From: Arden Thomas
Sent: Friday, March 19, 2021 4:44 PM
To: Jeremiah Cromie
Cc: Jeremy Johnston; Candie Leader
Subject: RE: SX-21-00003 Demarest Shoreline Exemption - Request for Comment

From: Jeremiah Cromie <jeremiah.cromie@co.kittitas.wa.us>
Sent: Thursday, March 11, 2021 8:54 AM
To: Arden Thomas <arden.thomas@co.kittitas.wa.us>
Cc: Jeremy Johnston <jeremy.johnston@co.kittitas.wa.us>; Candie Leader <candie.leader@co.kittitas.wa.us>
Subject: SX-21-00003 Demarest Shoreline Exemption - Request for Comment

JANUARY 2021
 YAKIMA RIVER AT DEAREST PROPERTY
 830 PEBBLE BEACH DRIVE, CLE ELLUM
 BANK STABILIZATION SITE PLAN
 DRAWING 2

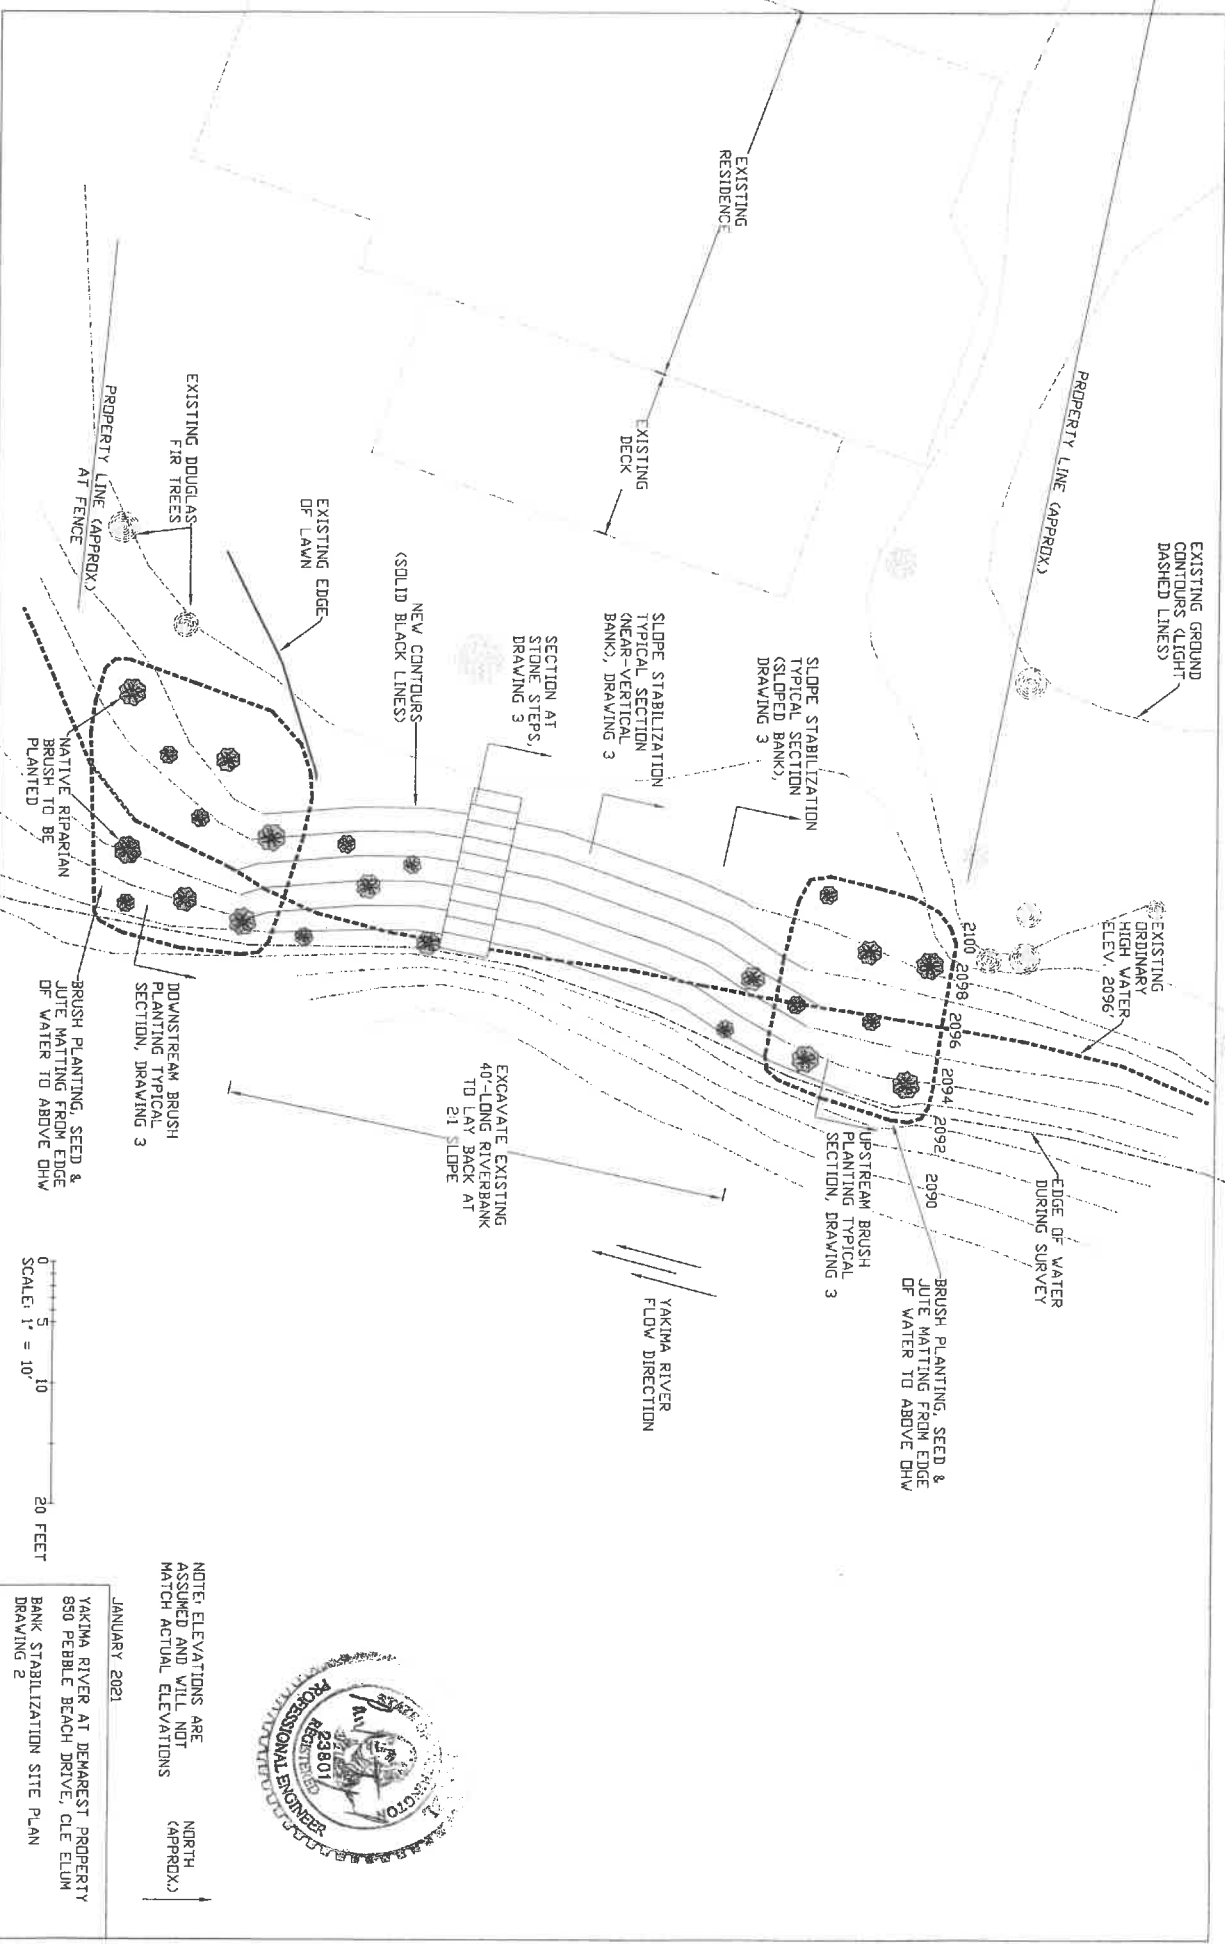
The proposed project will require a floodplain development permit and in particular will need to comply with Kittitas County Code 14.08.300 (Floodways). The design approach proposed, in which all paced rock will be located at or behind existing grade, and the existing bank will be sloped back, will help this project meet these code requirements.
